PLANNING BOARD REPORT PORTLAND, MAINE

Residential townhouse - 6 unit condominium
133 York Street
Level III Site Plan and Subdivision
Project ID 2013-187
133 York, LLC, Applicant

Submitted to: Portland Planning Board Public Hearing Date: November 12 th , 2013	Prepared by: Jean Fraser, Planner Date: November 8 th , 2013 Planning Board Report # 50-13
---	--

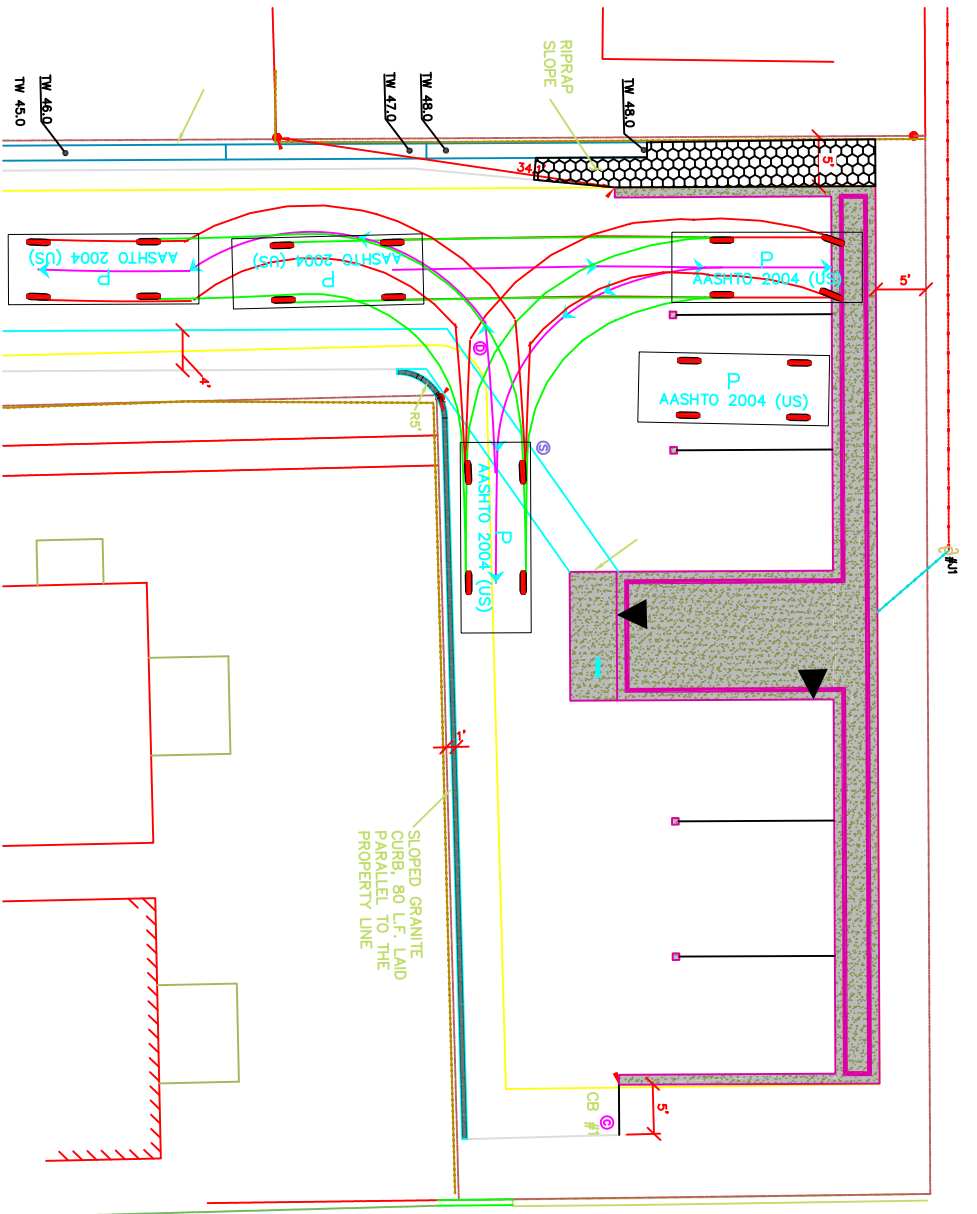
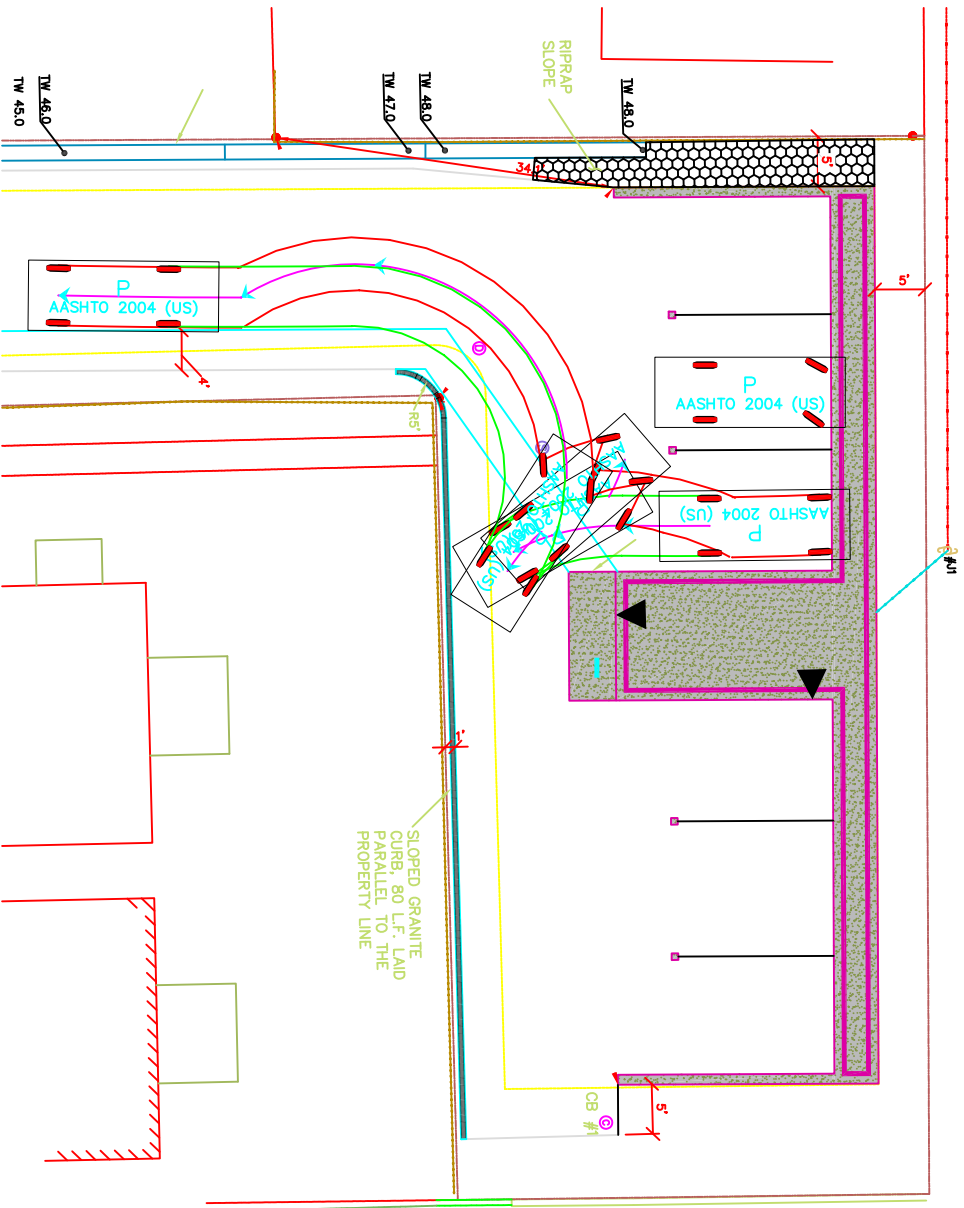
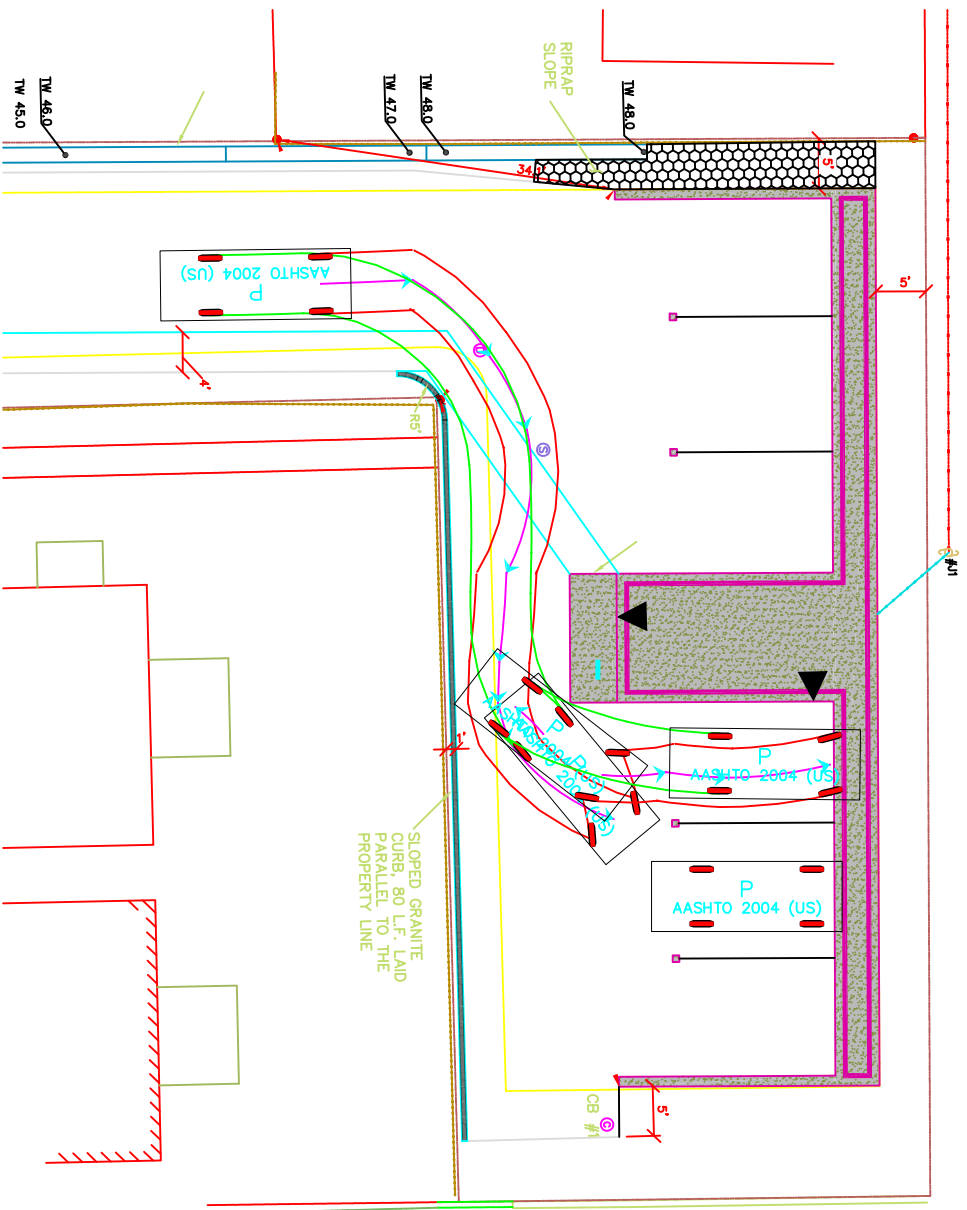
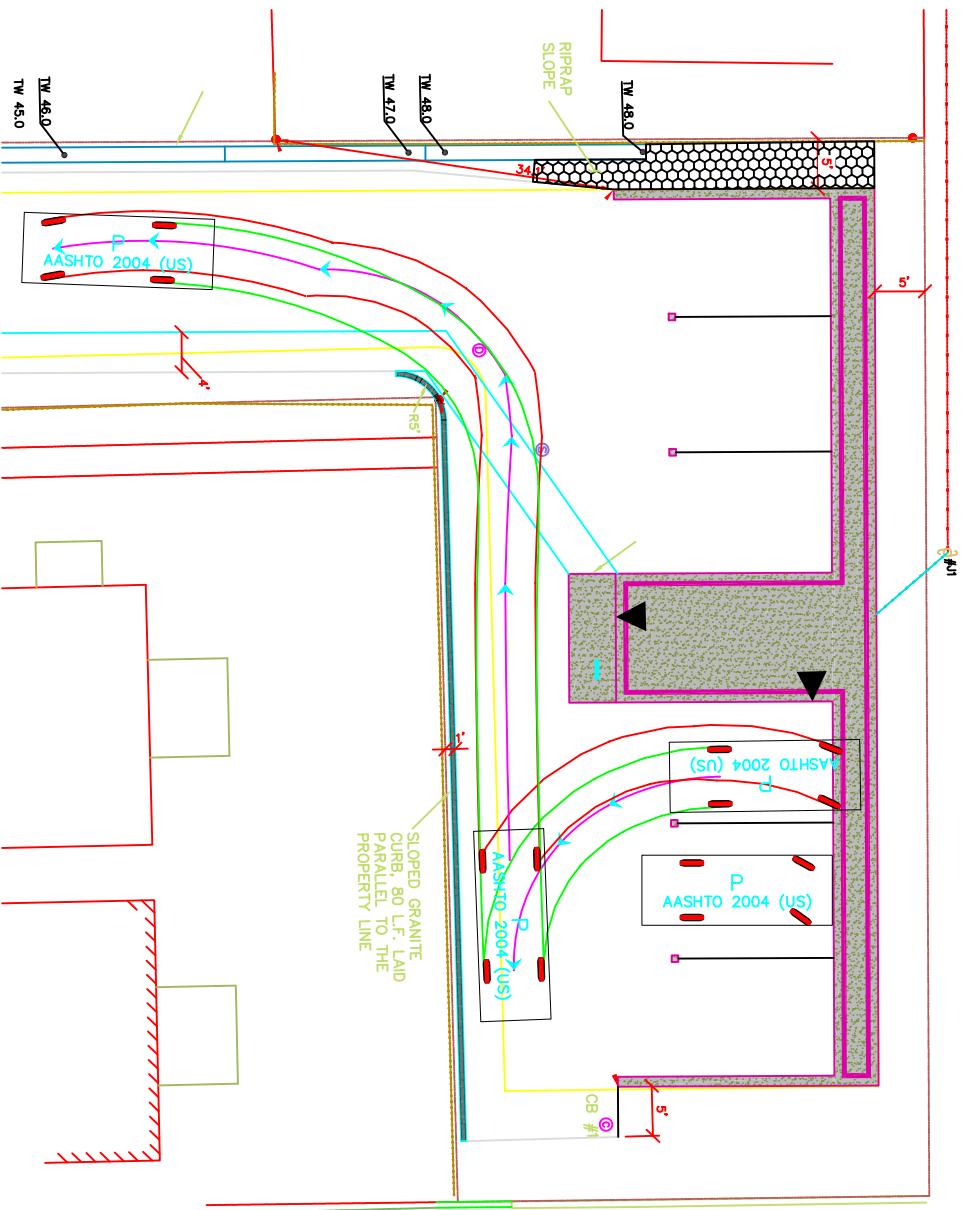
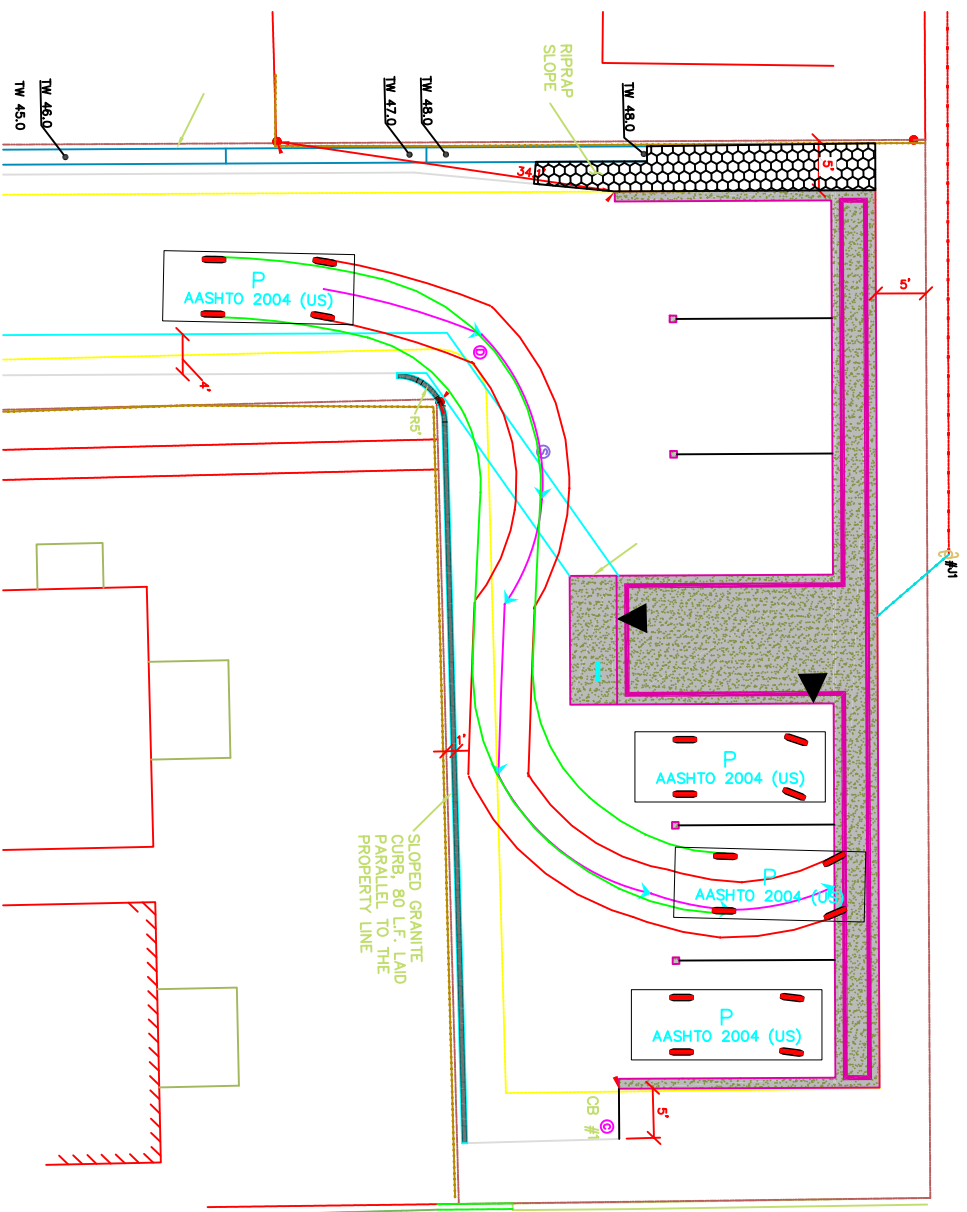
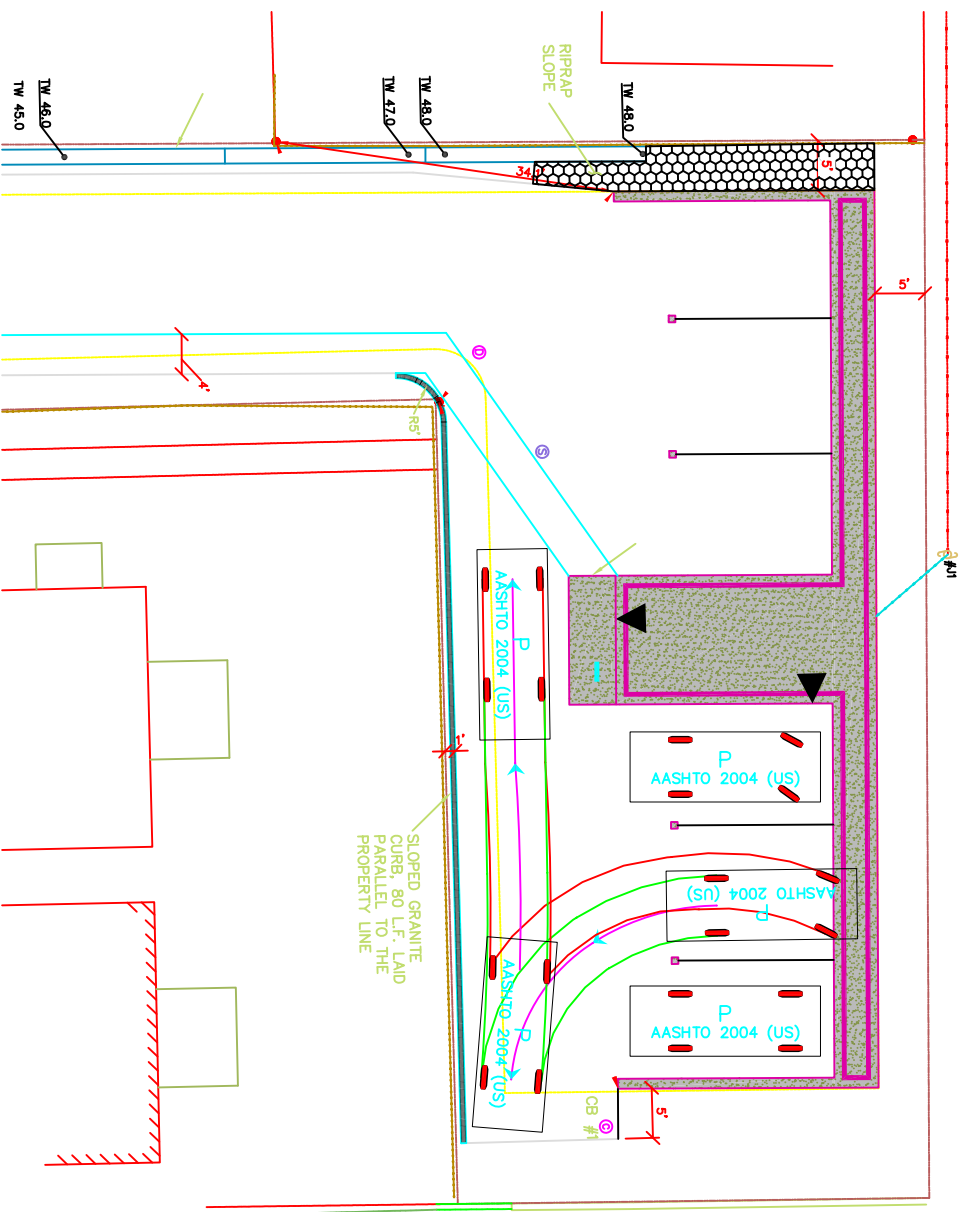
The size and placement of the building results in a narrow parking aisle leading to the 6 parking spaces located underneath the building. This potentially could cause congestion if the layout encouraged residents to back out of the drive onto York Street, which is heavily trafficked at this location near the bridge to South Portland. For this reason the Traffic Engineering Reviewer, Tom Errico, requested turning templates to illustrate the feasibility of access/maneuvering (Attachment 2). These were submitted and two of the parking spaces appeared

difficult to access (see [Attachment Y](#); an example is at right); Mr Errico wanted to confirm the adequacy of maneuvering space, as he has commented ([Attachment 14](#)):

- Access and egress movements into the garages appear difficult given the narrow pavement area. The applicant shall provide turning template graphics for a standard passenger car illustrating the ability of vehicles to adequately circulate on-site.

Status: The applicant has provided the requested turning template graphics. Given site constraints, I also requested that the applicant provide a simulated site layout in a parking area so that I could determine if vehicles could access/egress the parking garages. Based upon the field study, some garages will require multiple maneuvers (k-turns) to enter and exit the garages. The site is very constrained and the ease in which vehicles can make their intended maneuver will be a function of the design vehicle. My field simulation was based upon a Subaru station wagon and this represents a mid-size vehicle. Large Single-Unit Vehicles (SUV) will have greater difficulty.

With all that said, I do support a waiver from our technical standards for parking lot aisle width dimensions. The waiver is suggested given the unlikelihood that vehicles will back down the driveway into York Street. There is a significant distance between the garages and York Street, and thus feel that all maneuvers will occur on-site. I would note that the bicycle rack should be relocated so that it does not impede circulation. Additionally, it will be very important that snow removal/maintenance is effective so that snow does not further constrain the site.
